Appendix A - Response to Government and Independent Agency Submissions

Bays 1-4a Locomotive Workshop,
Australian Technology Park, Eveleigh
SSDA 8517

Submitted to Department of Planning &
Environment
On behalf of Mirvac Projects Pty Ltd

07 June 2018 17068

4.9.6 Roof Plant Platforms

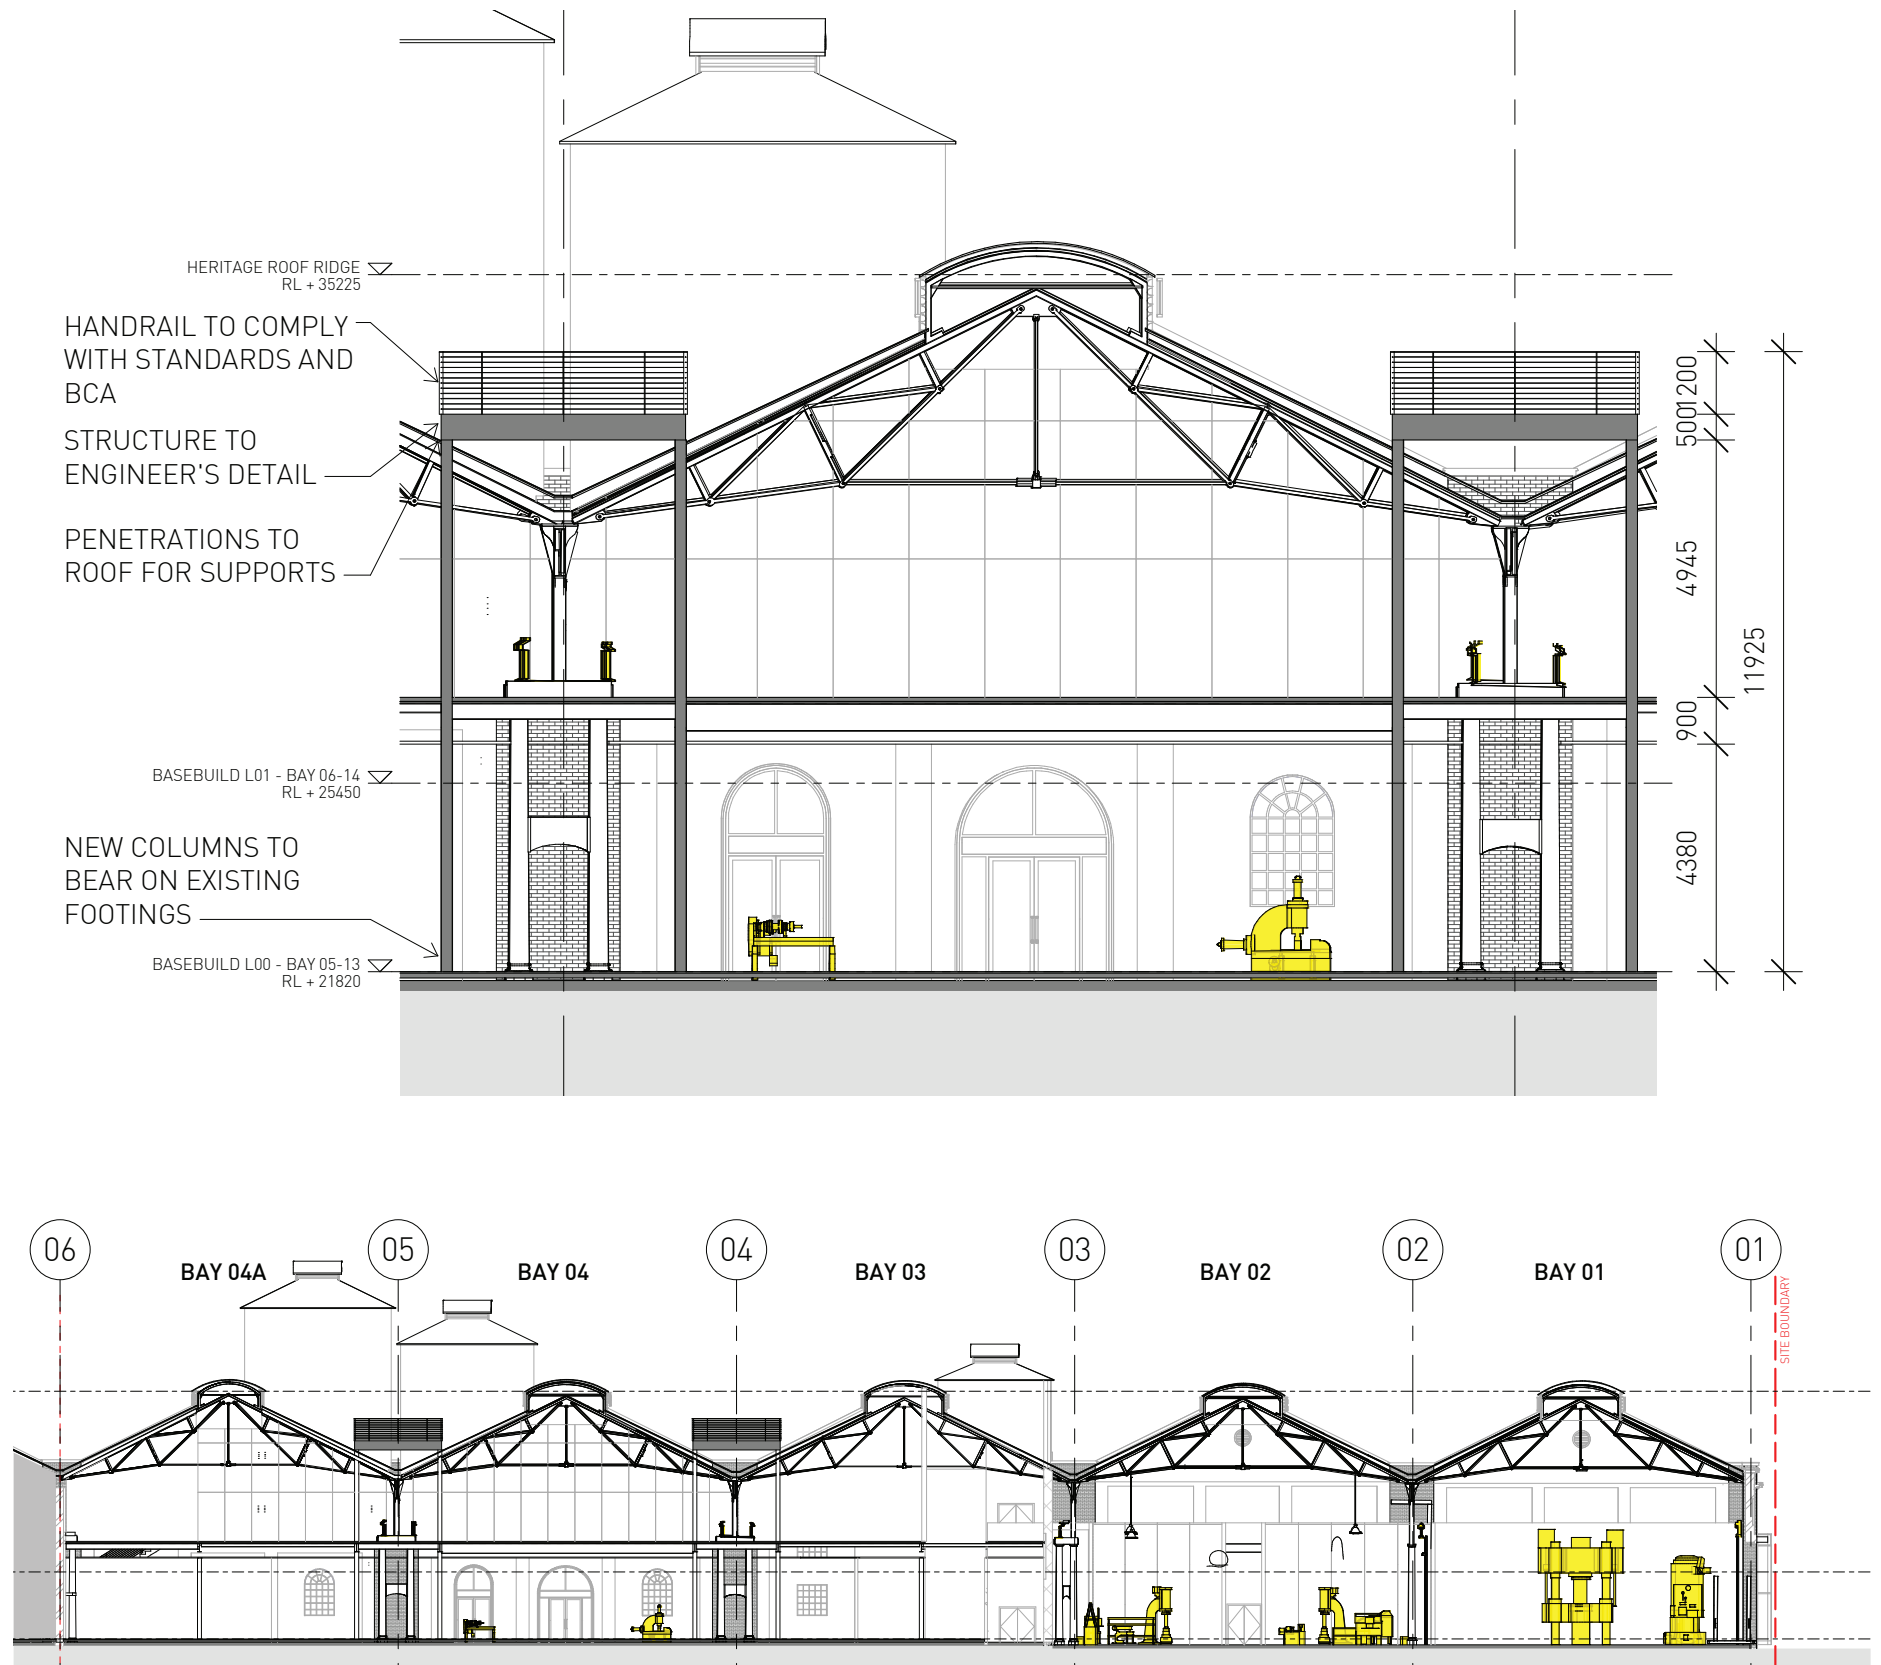
It is recommended that design details of the roof plants and their structural supports be provided to the City of Sydney for review and comment prior to the issue of a Construction Certificate.	✓	✓	Section 4.4.2	Noted. A suggested condition of consent is included at Appendix G .
The City questions the necessity for the signage on the exterior of Bays 4 and 4a.	✓		Section 2.8	
It is recommended that the signage proposals should be rationalised, integrated and consistent with the Interpretation Strategy (November 2016) prepared by Curio Projects.	✓	✓		As set out in the Heritage Response Report, the proposed signage zones should not be included within the Stage 2 Interpretation Strategy for the Locomotive Workshop, as only signage that is considered to be 'interpretative' should form part of the interpretation strategy. Notwithstanding this, new bay numbering signs at ground level will be provided in conjunction with the Stage 2 Heritage Interpretation Strategy for the Public Domain and pursuant to a separate application.

4.10.2 Junction with Heritage Wall

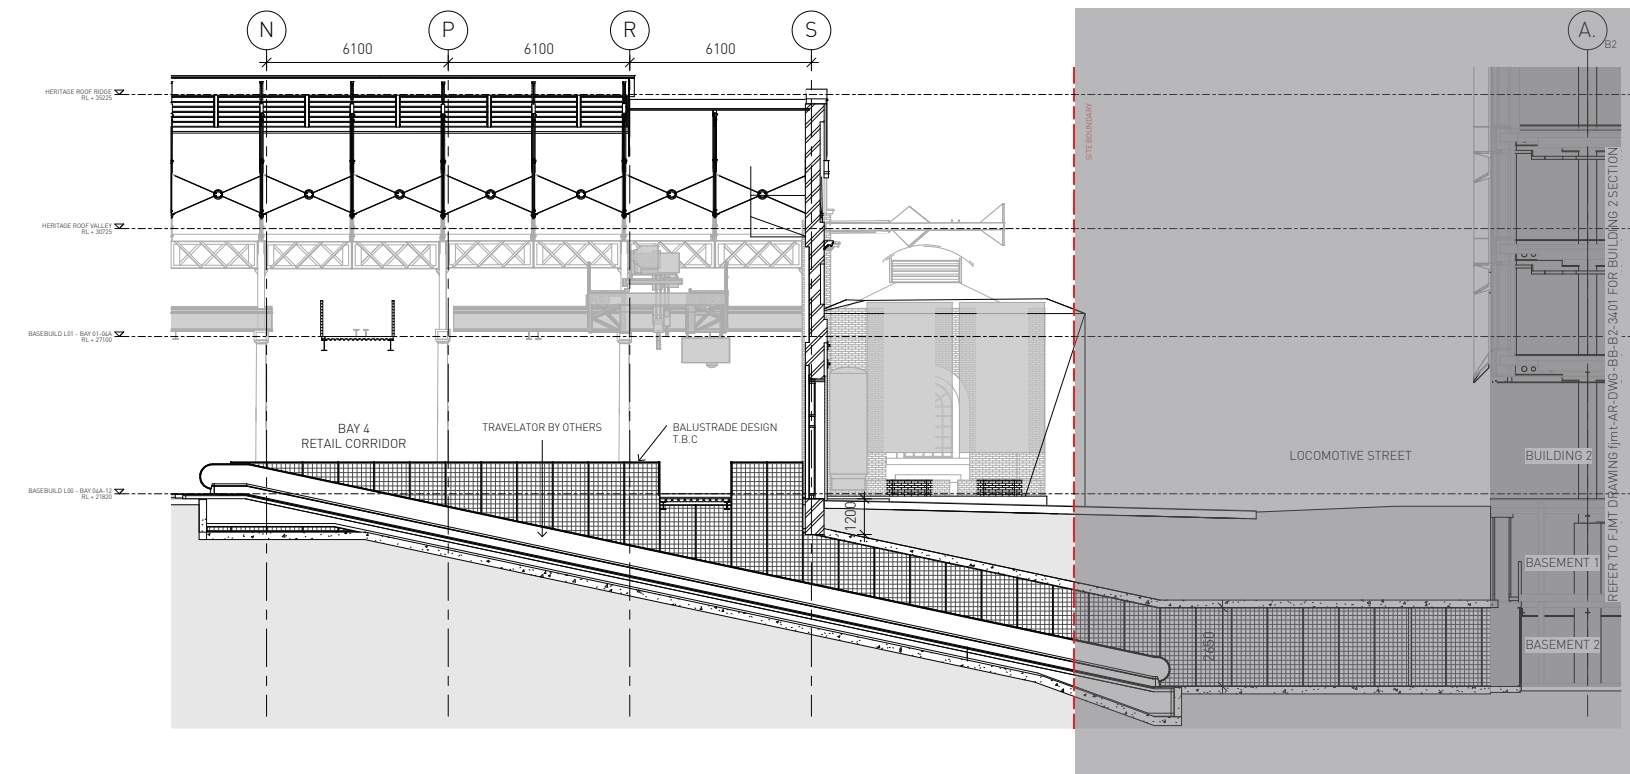
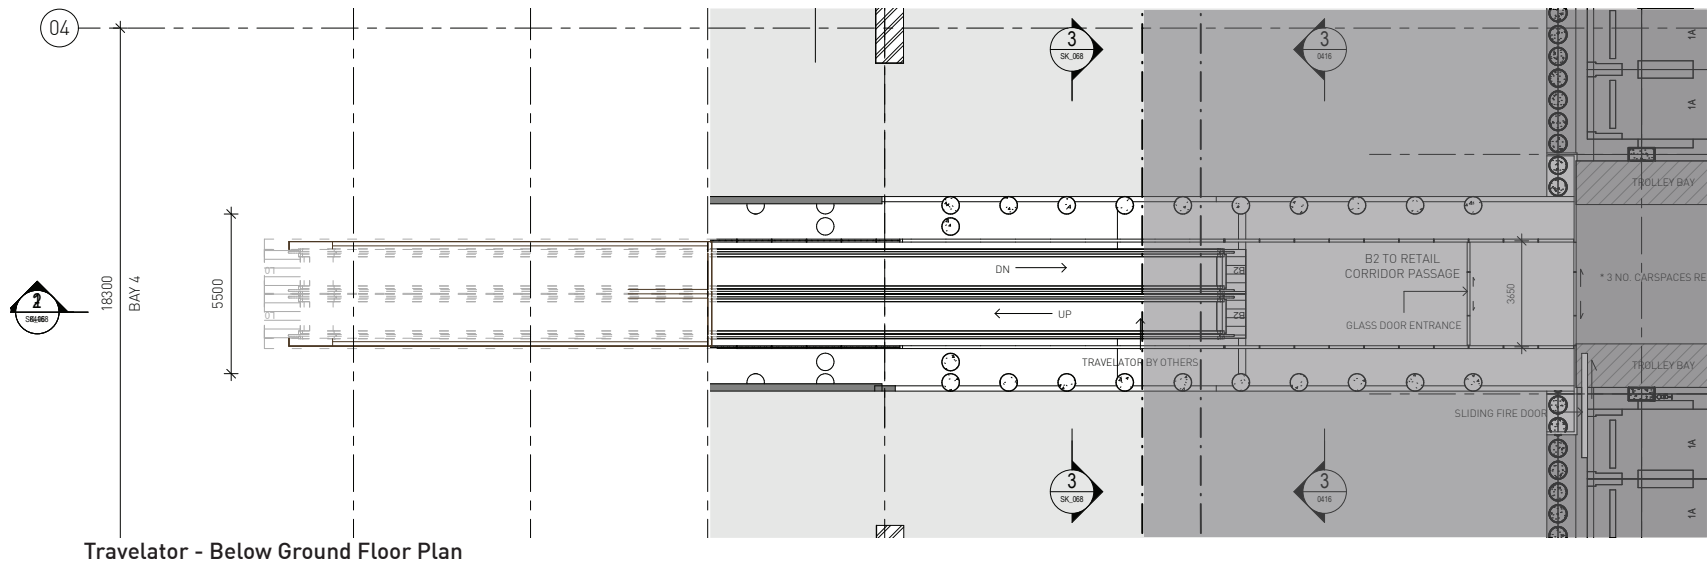
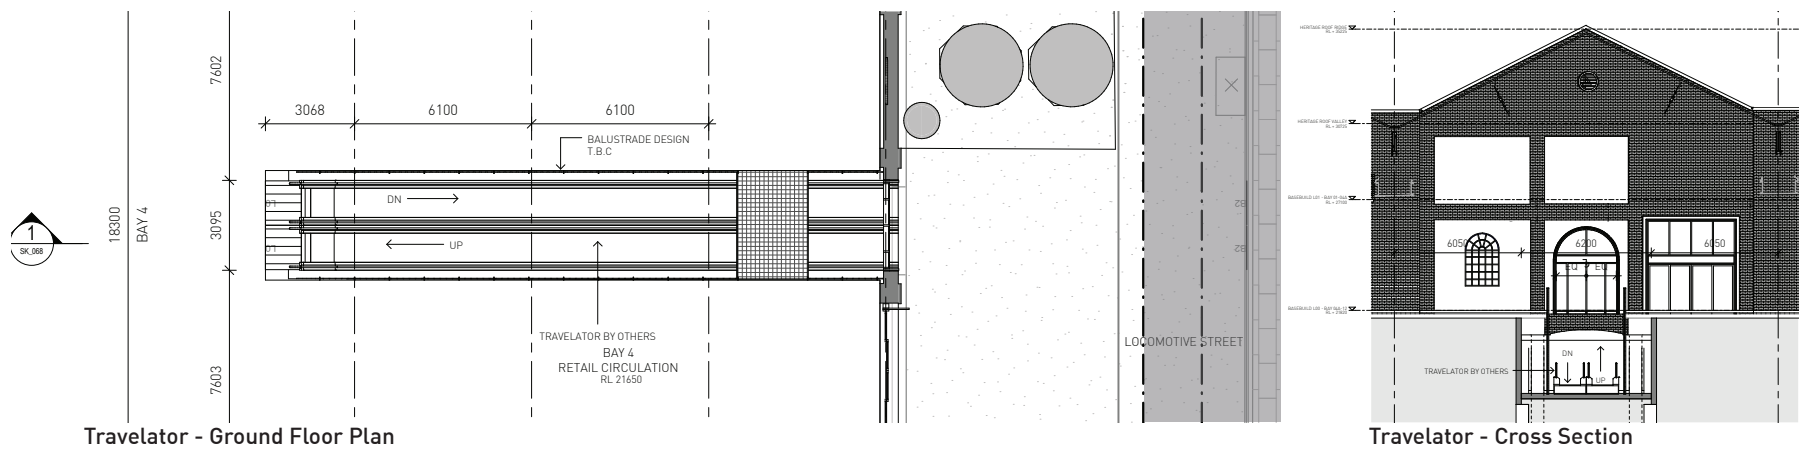
Extract	SSD 8157 (Bays 1-4A)	SSD 8449 (Bays 5-15)	Reference in SSAD 8517 RTS Report	Response
Confirm whether the southern wall of Workshop will require additional strengthening.	✓		Section 2.9	
Address the inconsistencies between the architectural drawings and the perspectives of the proposed Travelator and existing arched footing of the Southern wall.	✓			The revised Architectural Drawings (Appendix C) and Response to Submissions Package (Appendix M), both prepared by Sissons provide correct information on the Travelator and the existing arched footing.
The rationale for the travelator is based on economic arguments. It is considered there are other options to provide access from the car park that will not impact the Workshops. Further design details must be provided to the Heritage Council for assessment prior to approval of this project.	✓		Section 2.18	
Loading Dock				
Prior to approval by the Heritage Council for this project, provide further design resolution of the proposed Loading Dock, including the proposed insertion of a mezzanine level interpretation gallery within the core Bays 1 and 2 heritage area.	✓		Section 2.15	Section 4.13 provides further detail on the loading dock design and as set out in Section 4.3, the principal aim of this SSDA is to gain approval for the key concepts, as listed. Section 4.4 clearly sets out that the detail of the construction methods, materiality and detailed design that will be provided either as part of the construction certificate documentation or which will be is subject to a separate approval. Suggested conditions of consent in relation to this strategy are included within Appendix G .

Mezzanine plan Bays 1 and 2

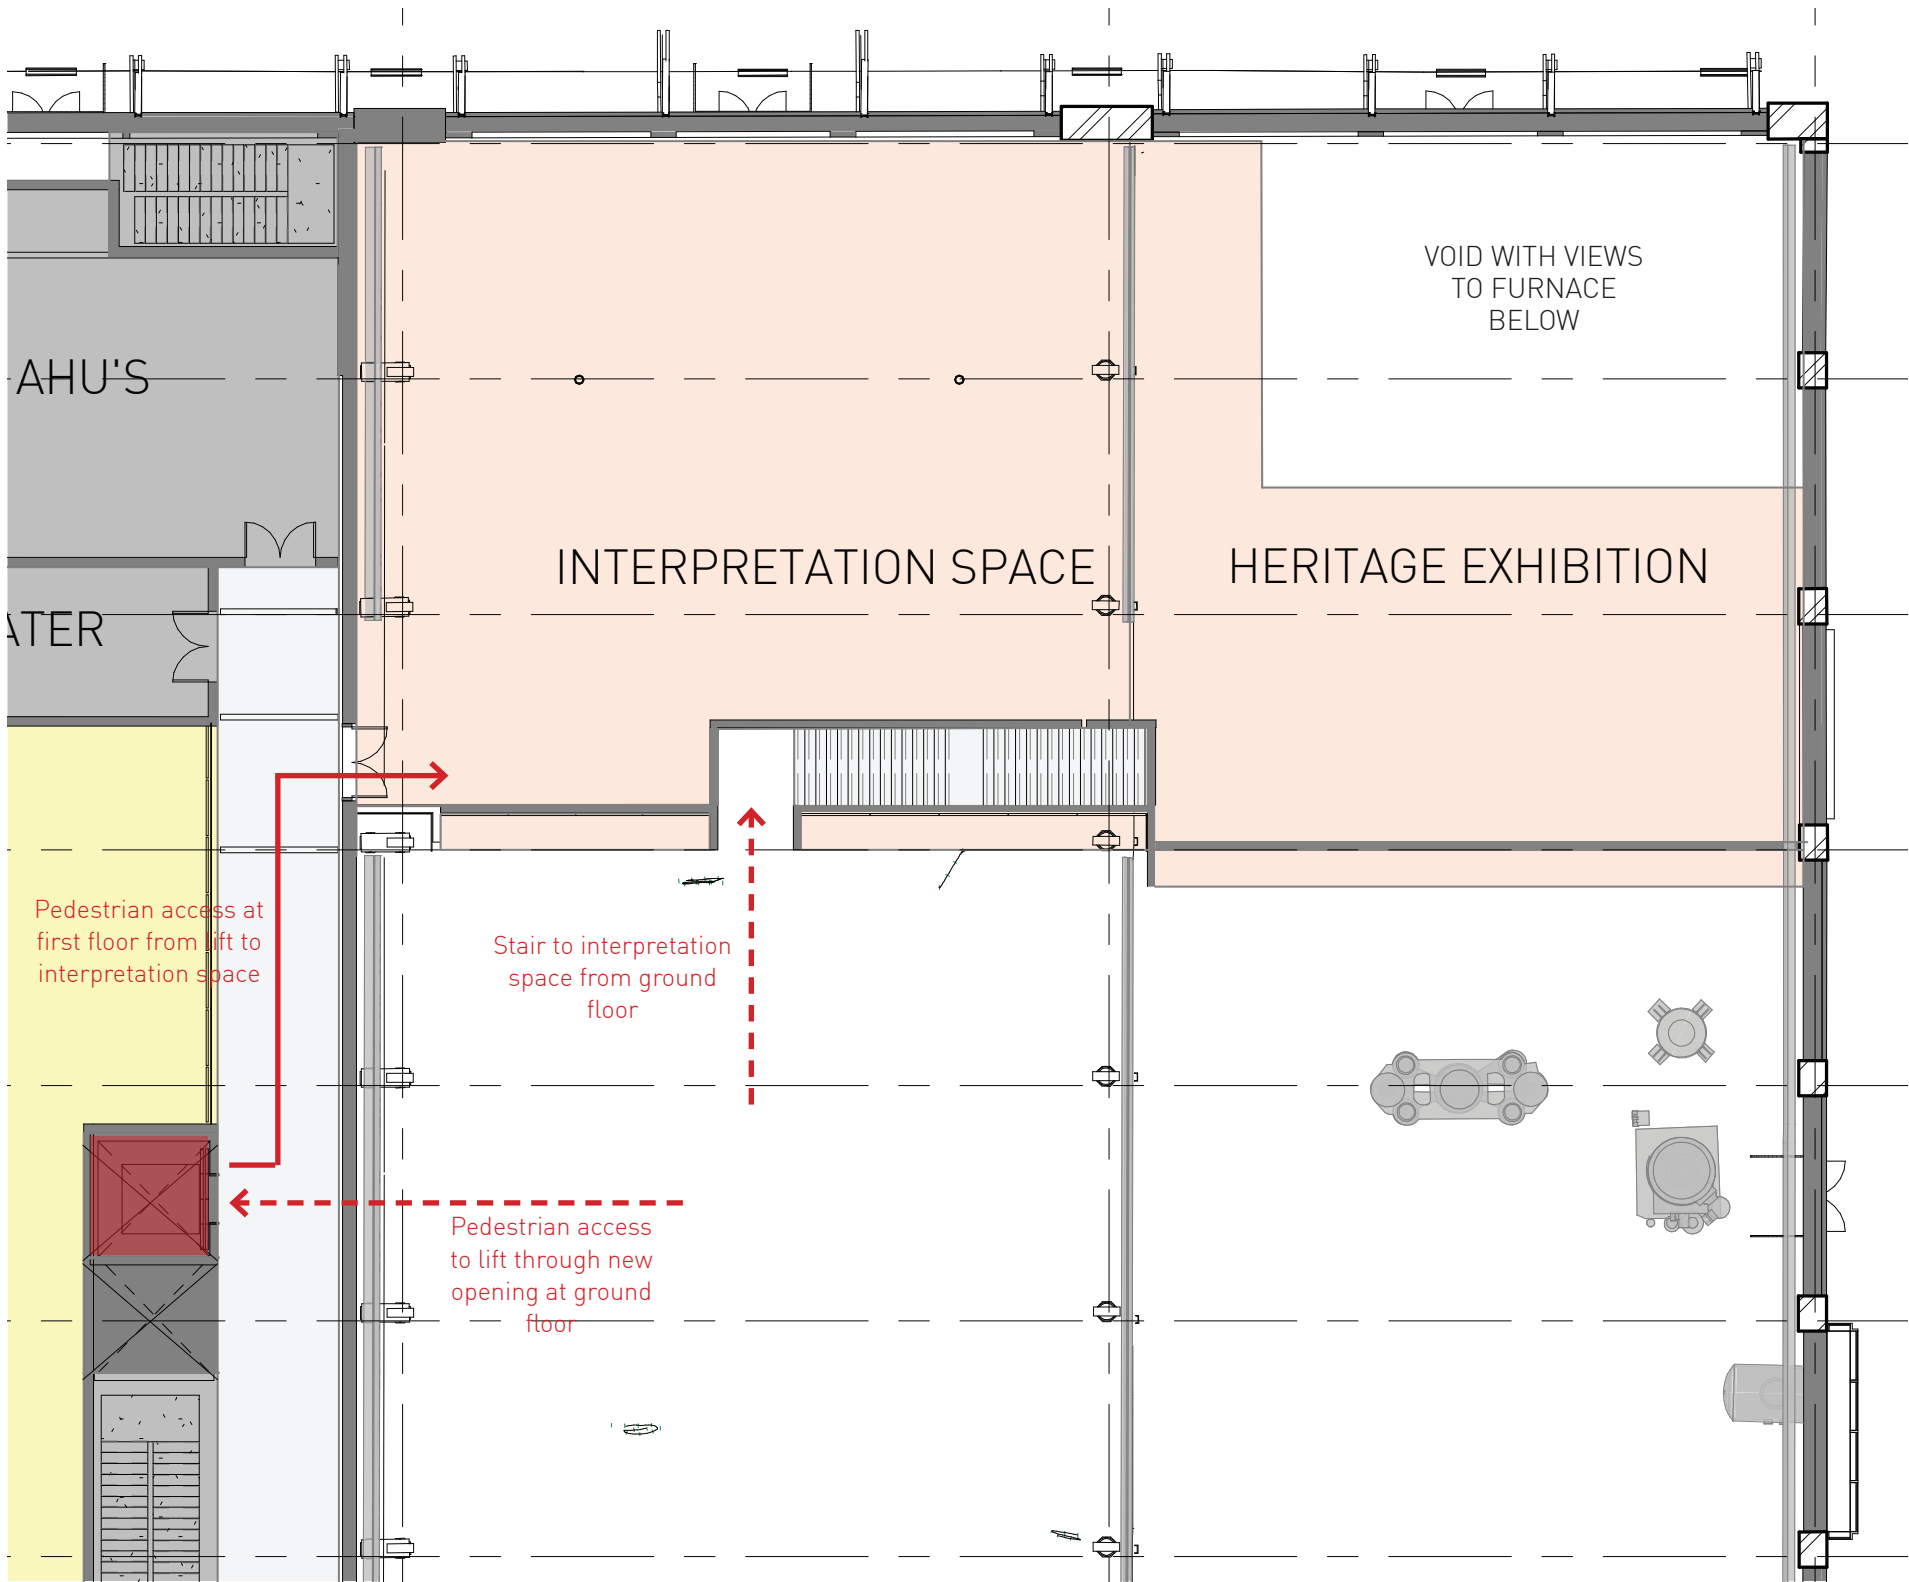
Extract	SSD 8157 (Bays 1-4A)	SSD 8449 (Bays 5-15)	Reference in SSAD 8517 RTS Report	Response
vehicles. Further design details must be provided.				
Bay 1 & 2 Mezzanine Level				
Relocate the access to lift to Bay 2 to consolidate access points to the interpretation mezzanine space.	✓		Section 2.5 & Section 4.20	As explained in Section 2.5, the stairs have been relocated to Bay 3 to provide public vertical access facilities within one location. The design rationale is included in Section 4.20.
Blacksmith				
It is unclear if operations in the reduced Blacksmiths areas require any physical separation from other proposed uses in terms of reducing noise and fumes. It is important that a strong sensory and experiential connection is maintained between the Blacksmith area and the broader space.	✓		Section 2.10, Section 4.18 & Section 4.21	The EIS and Response to Issues Report for the proposed development demonstrates Mirvac's commitment to the ongoing use of the blacksmithing equipment by the existing Blacksmith operation. Further, it seeks to support the existing Blacksmith operation through the provision of an upgrade to the fit-out of this area, replacement of broken furnaces, the provision of a specific Blacksmith viewing platform and integration of the Blacksmith's 'shop front' to be integrated with the primary Heritage Interpretation and exhibition zone.
